Further to your letter, please see my responses to comments 1, 2 and 3 from your letter (your ref: NE/21/00001/FUL):

The amended drawing 53 FD 001 B is attached.

Proposed First Floor Plan

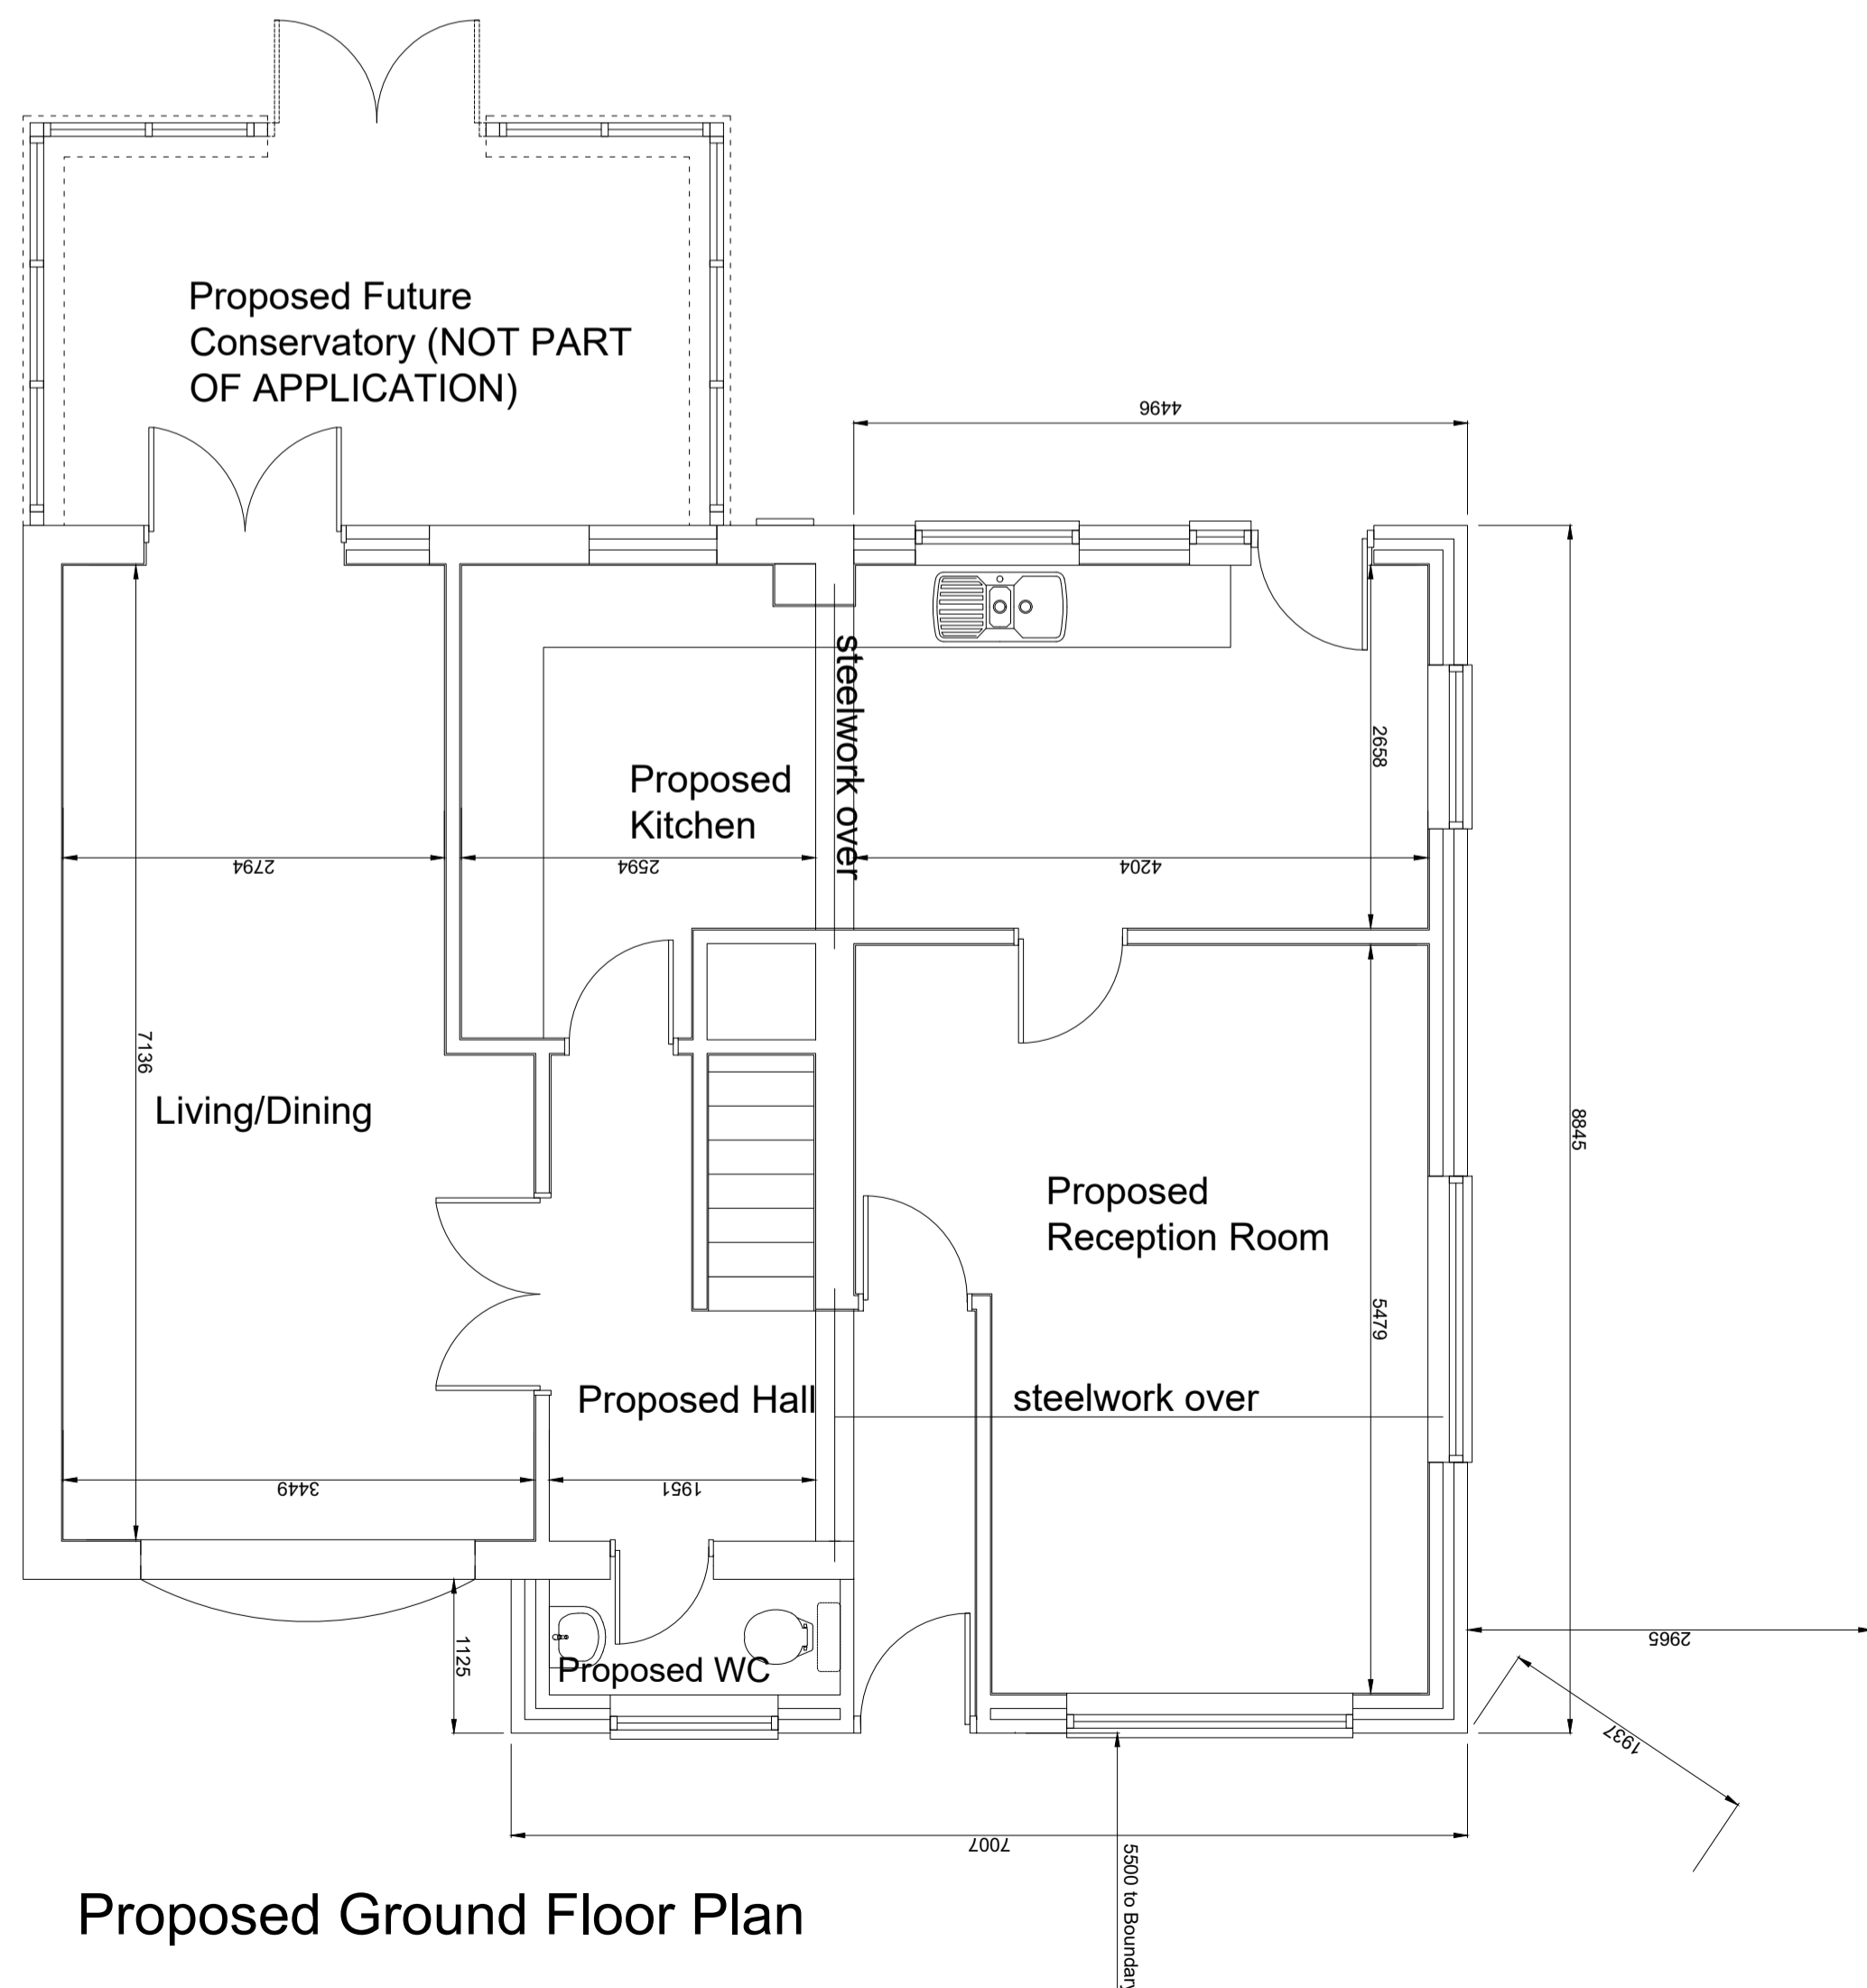
- 1: I confirm I accept the amended description as set out in the letter.
- 2: The proposed conservatory is not part of this application. A note has been added on the drawing to clarify this (see attachment).
3. Dimensions including relevant boundary dimensions are now included in the amended drawing (see attachment).
